Development Facilitation Team (DFT) – Review Comments

DRB Project No: PR-2020-003484 Date: 06/14/2023 Agenda Item: #4 Zone Atlas Page: E-10

Application For: SD-2023-00048 – PRELIMINARY PLAT (DHO)

DRB Project Number: 2020-003484 Hearing Date: **06-14-2023**
 Project: Mojave Ridge Subdivision Agenda Item No: 4

3 SCOUR WALL SECTION
Scale: HORIZONTAL: 1"=20' VERTICAL: 1"=10'

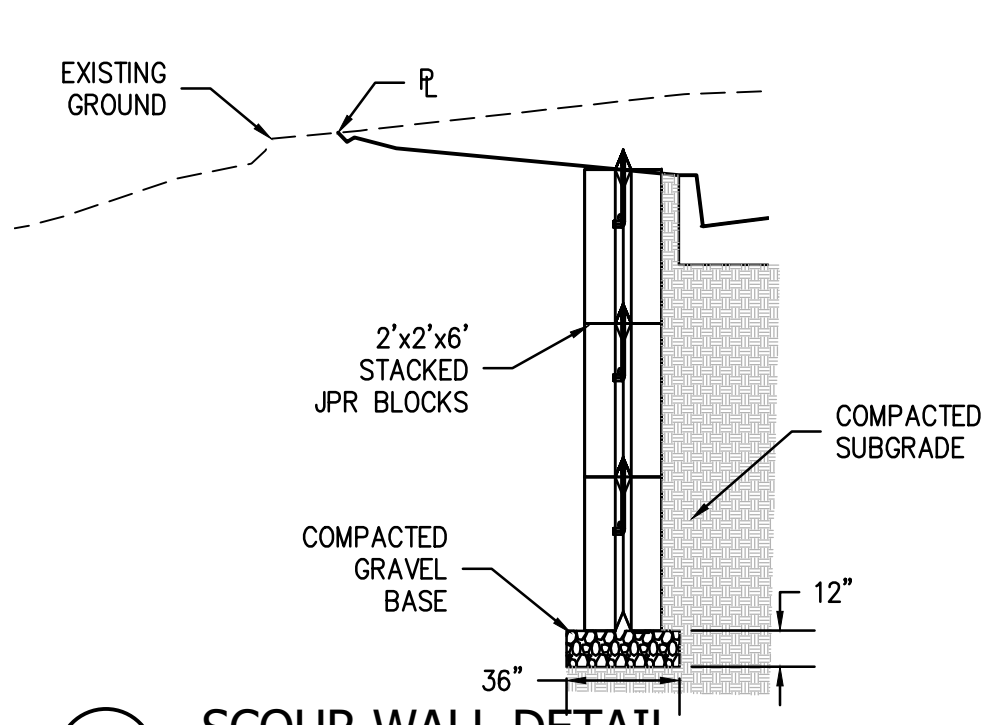
1. I see the Grading and Drainage plan shows Colton St. as a separate tract in order to keep the scour wall out of the ROW. Please ensure this is on the plat that we are approving. No objection.

PLAN AT C-C

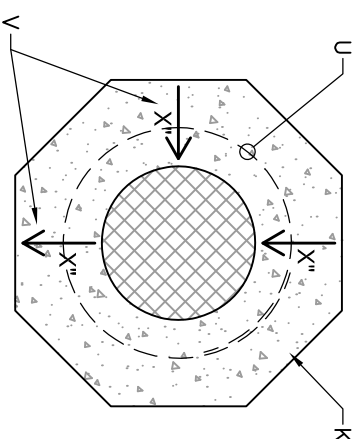
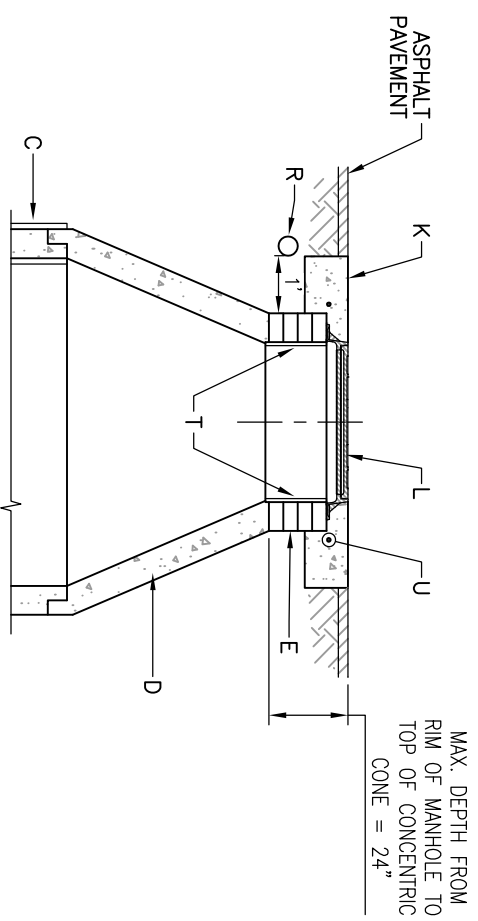
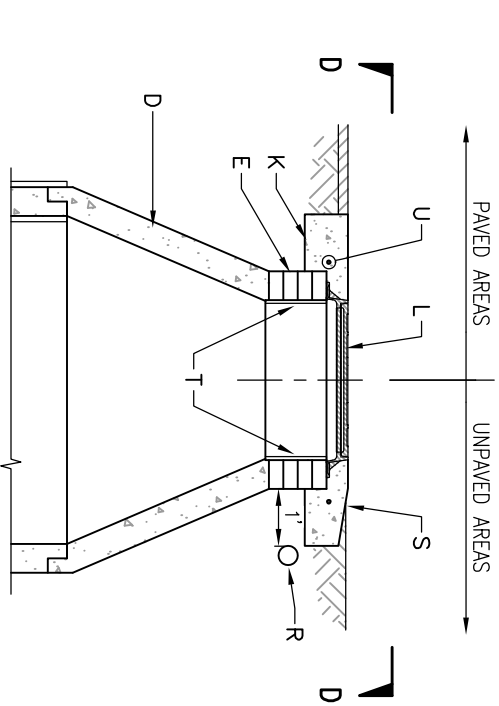
In addition to the SF-299 application form, please submit detailed drawings of the proposed sewer line, construction documents providing information on the depth, width, and length of the trench needed for the placement of the pipe, the dimensions of the pipe, what type of equipment would be used, duration and timing of the work, how much of the line would actually be within the Monument boundary, access and staging areas for construction, and how the line would be protected from spills/breakage since it would be located within the arroyo.

Locating a sewer line in an arroyo is a concern to us. We urge you to consider other options outside the Monument boundary. Have you considered connecting the development sewer line into the main line that is located within the Mojave Street NW corridor? What is your justification for connecting to the sewer line through the arroyo, and not connecting to the existing sewer lines located within the adjacent city street?

The existing sanitary sewer line is constructed within a Public Easement and is not within the physical arroyo. The 10 feet of sewer line and manhole will be constructed under the Standard Specifications The City Standard Drawings and Specifications of the connection are available and are attached. This "Public Easement" existed prior to the creation of the monument. Your opinion revokes the public interest in the easement without regard for Act. The 2023 Cooperative Management Agreement was intended for the Visitor Center and access and can't amend Federal Legislation.

**MOJAVE SUBDIVISION**  
 GRADING AND DRAINAGE  
 GRADING PLAN

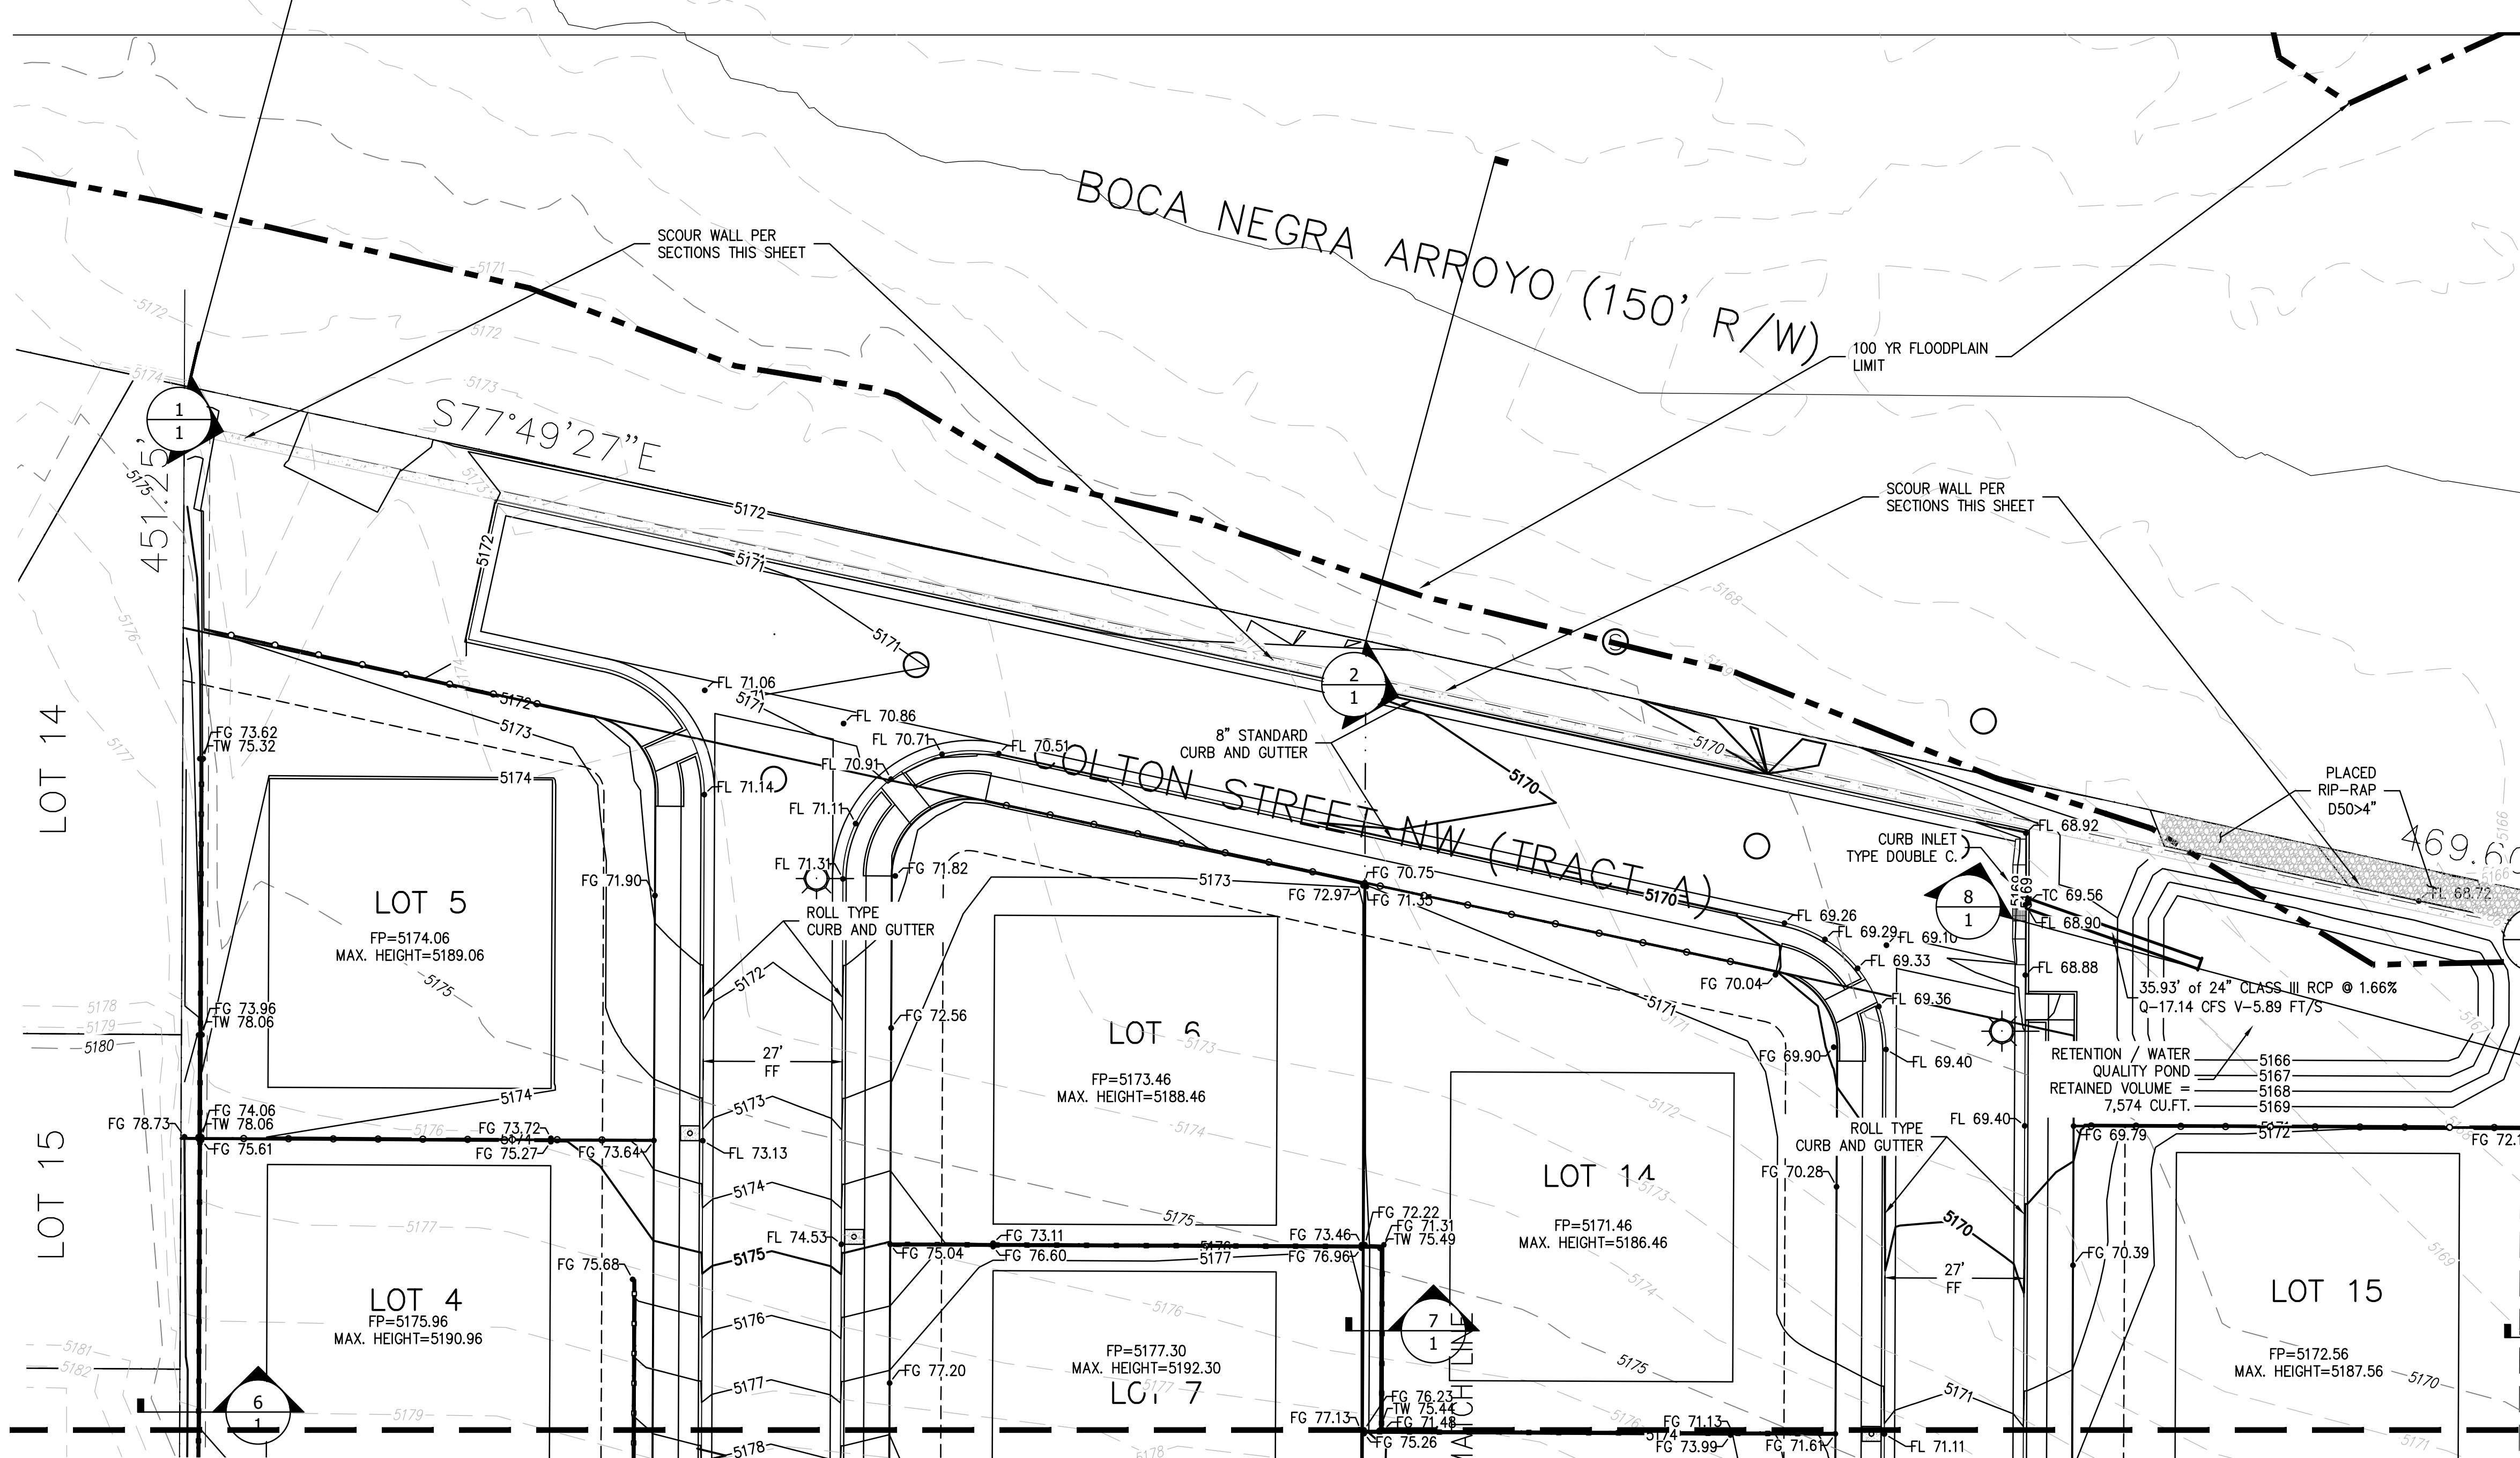
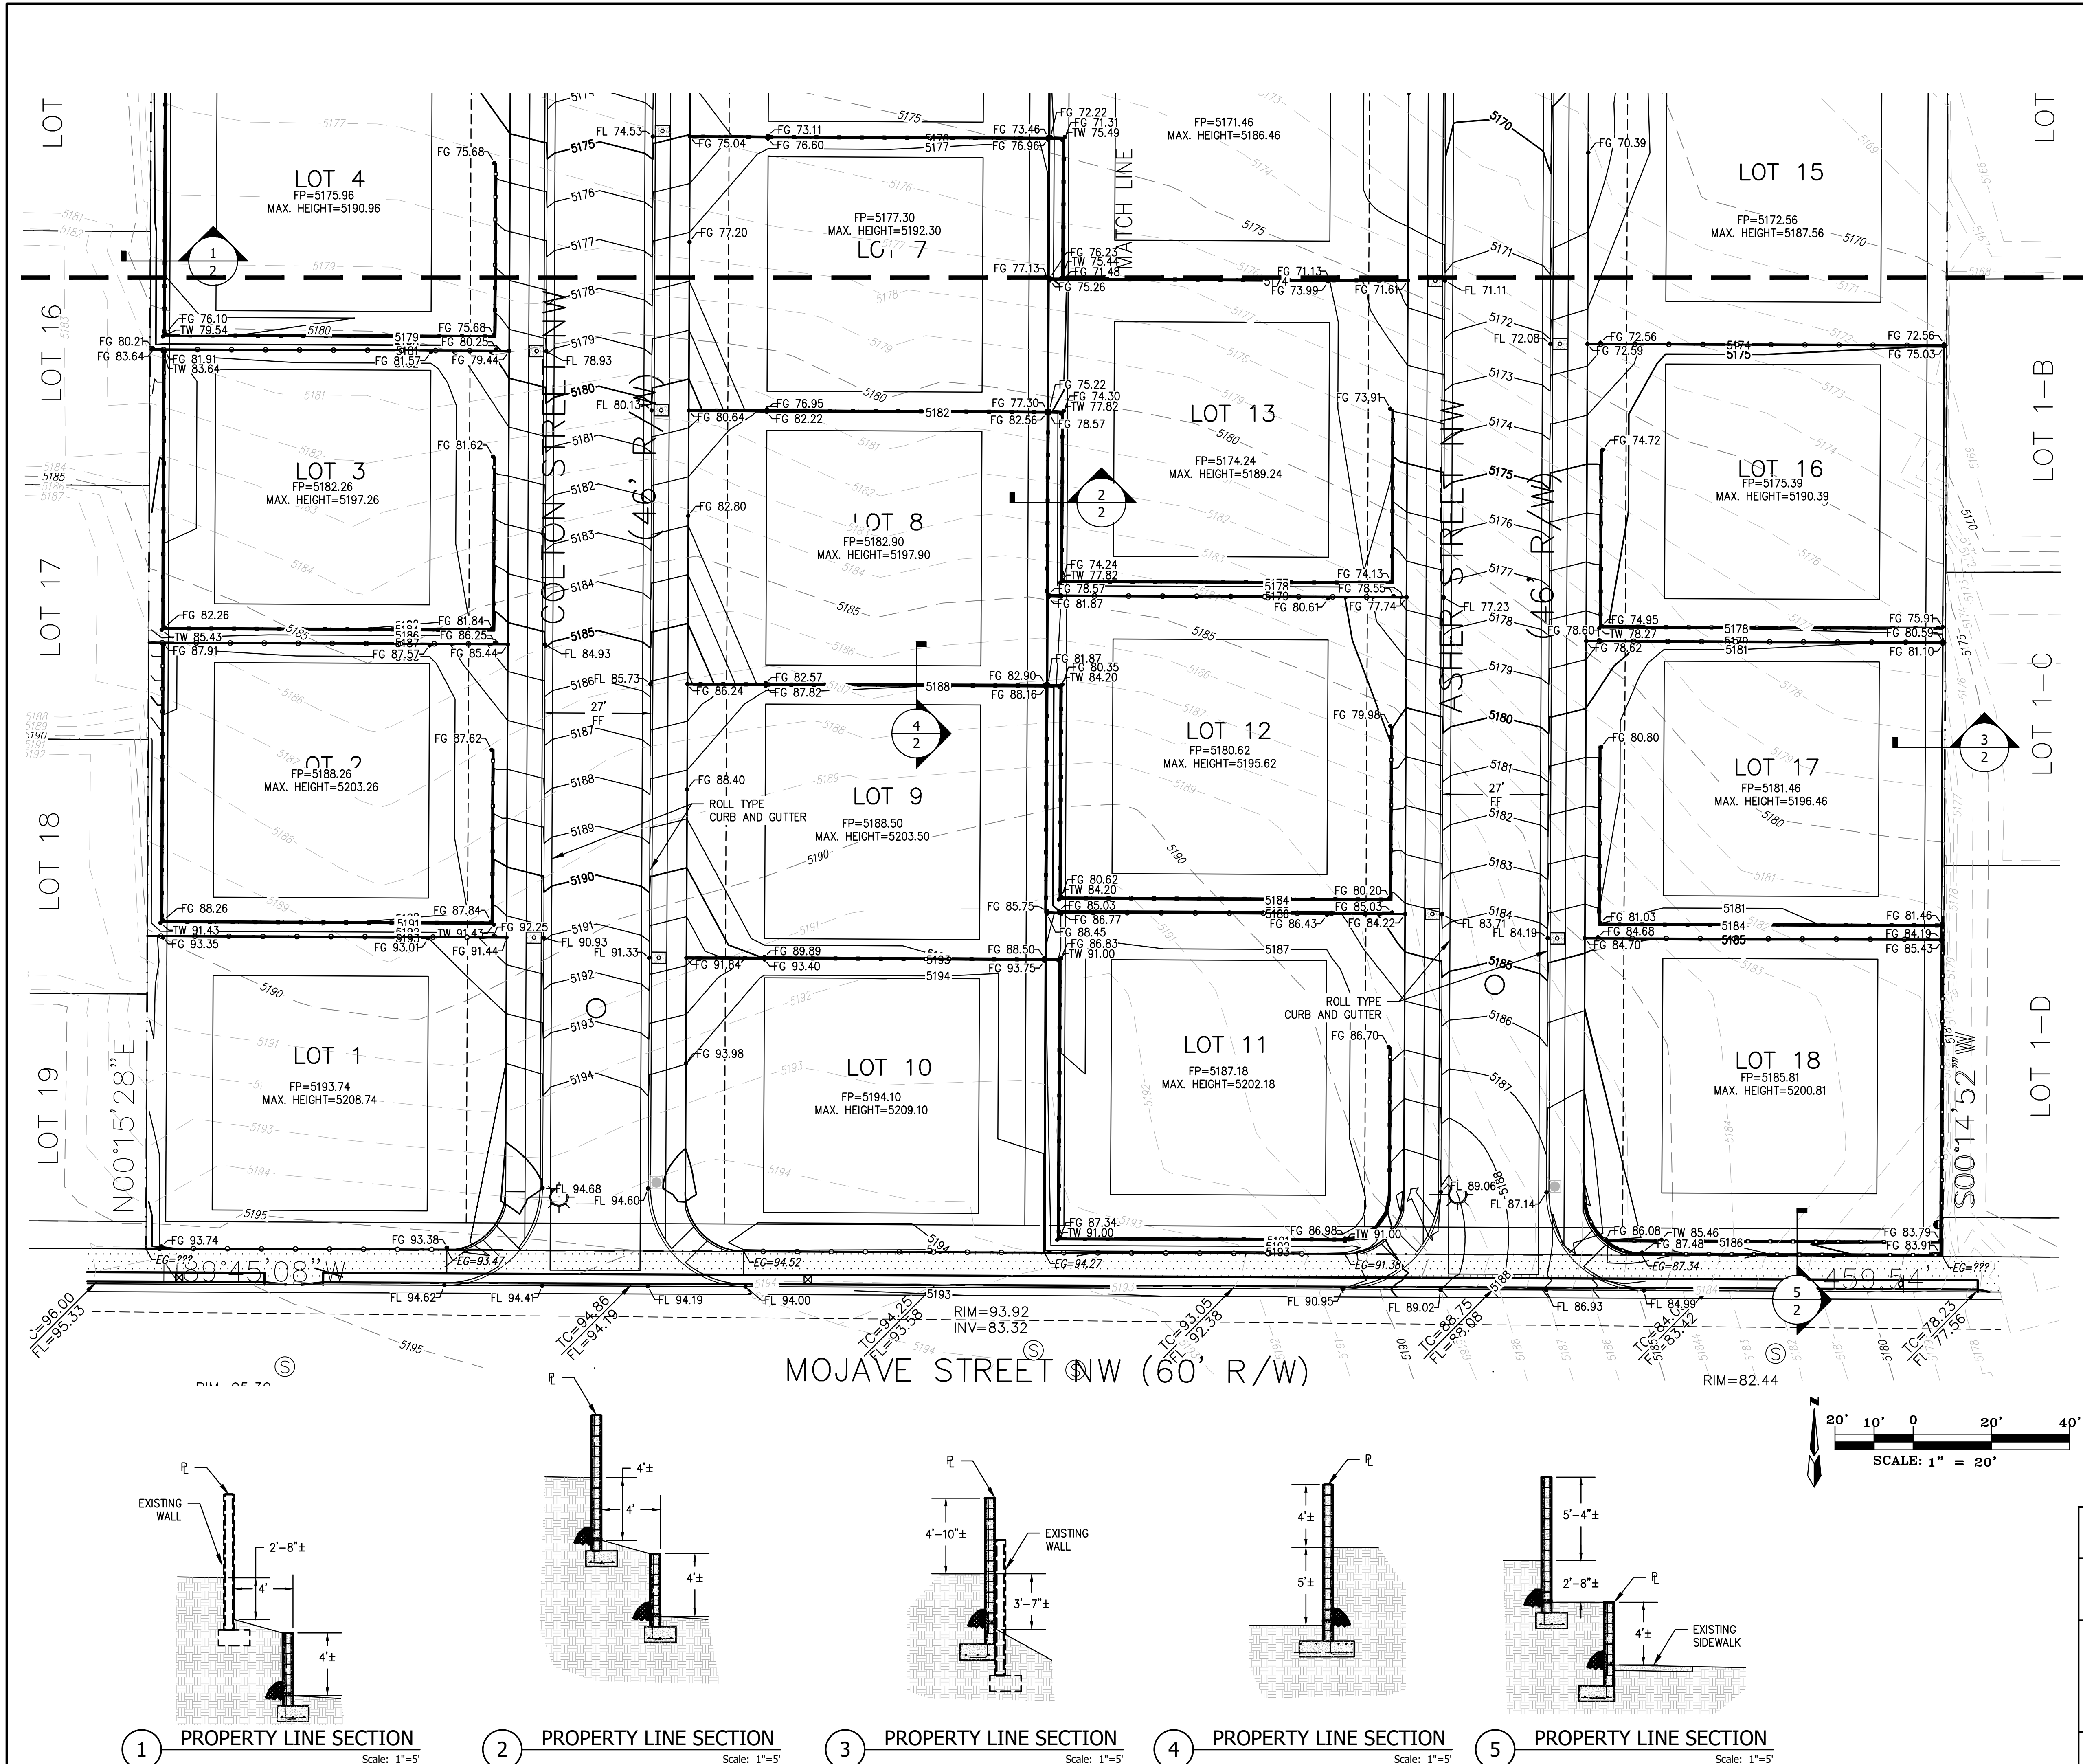
- Hydrology has an approved Revised Grading & Drainage Plans (E10D024) with engineer's stamp date of 05/15/23.
- Hydrology needs approvals from National Parks and Open Space.
